Application number: 2026/N/91744/E	
What is the application for?:	Prior notification for erection of agricultural building
Address of the site or building:	Land at, Leys Lane, Emley, Huddersfield
Postcode:	HD8 9TA

SITE PLAN AS PROPOSED

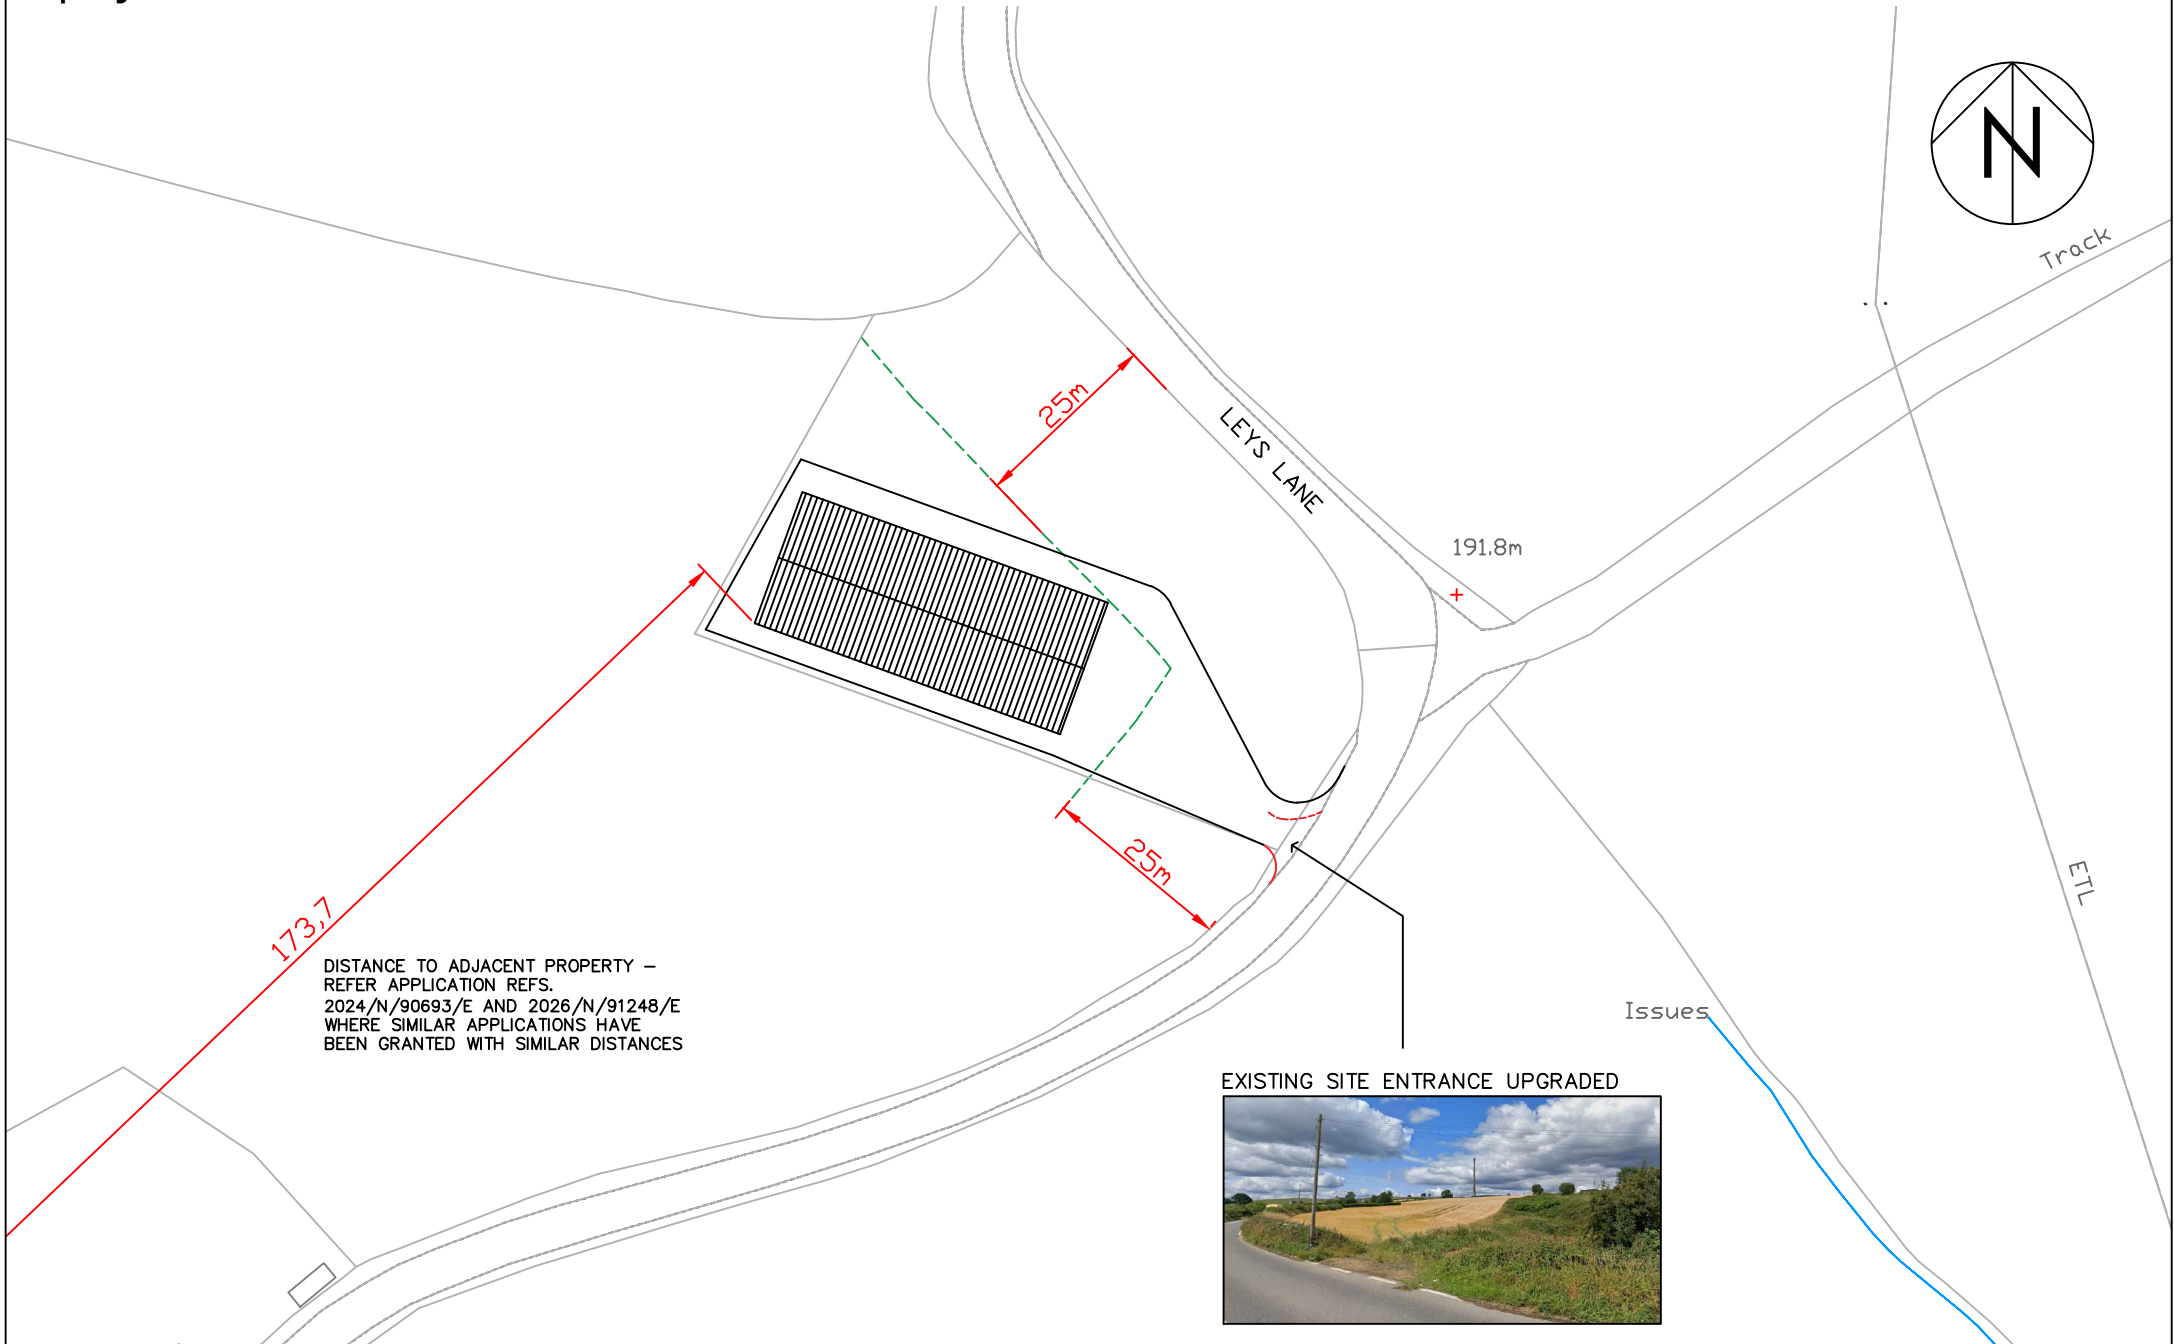
Type of comment: An objection	
Do you wish your comments to be published on the website anonymously?	Yes
<p>This proposed building is to be located with road access on a bend which has already seen many accidents. Slow moving agricultural equipment will add further risk to traffic movements. Additionally there is a history of the owner mounting bright security flood lighting to his other premises in the vicinity and if similar unrestricted lighting here is permitted, this again will enhance risk to night time drivers negotiating the bend.</p>
